Subject: RE: 16, Vicarage Lane, Felpham - FP/104/18/HH

sheet 4 of 6

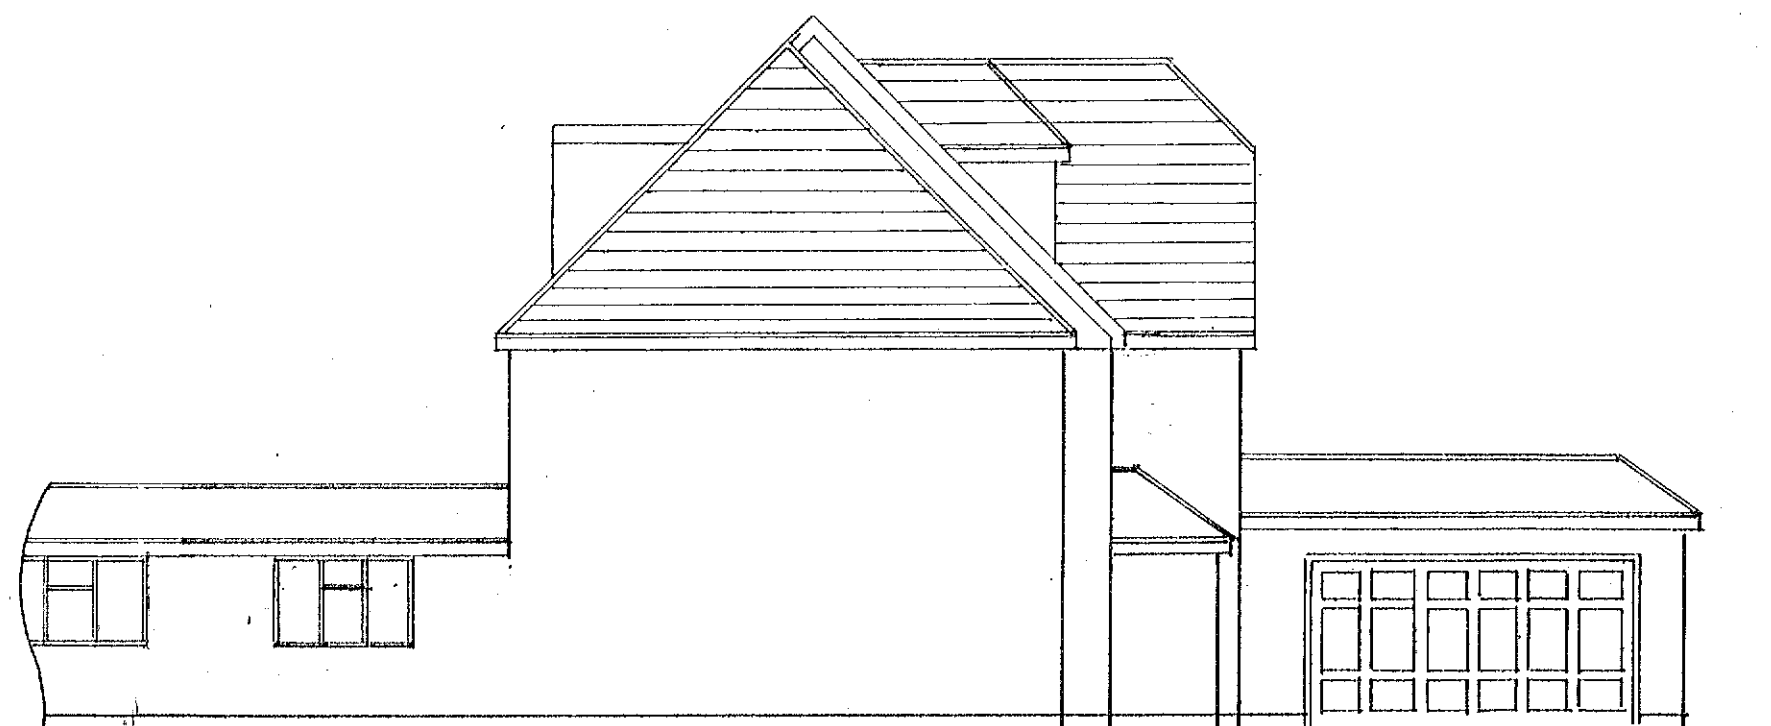
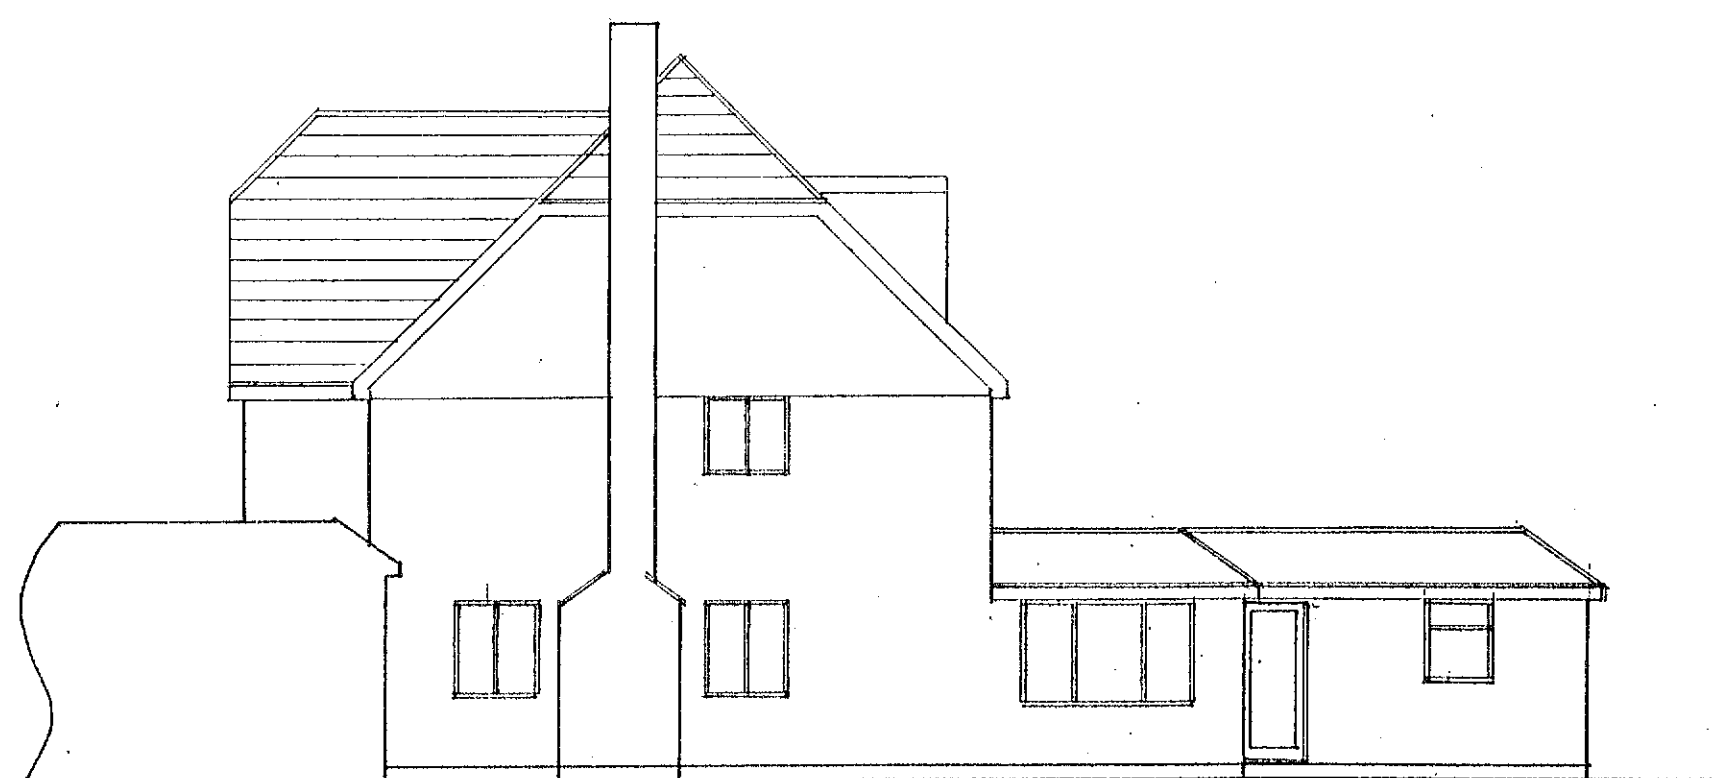
However, you should note that I have spoken with the Conservation Officer about the proposal and it is our view that the addition of the front dormers and the raising of the roof height will result in a dominating impact on the street scene and result in harm to the setting of the Conservation Area opposite and the setting of the Grade 2 Listed Building diagonally opposite. Therefore, my decision will be a refusal.
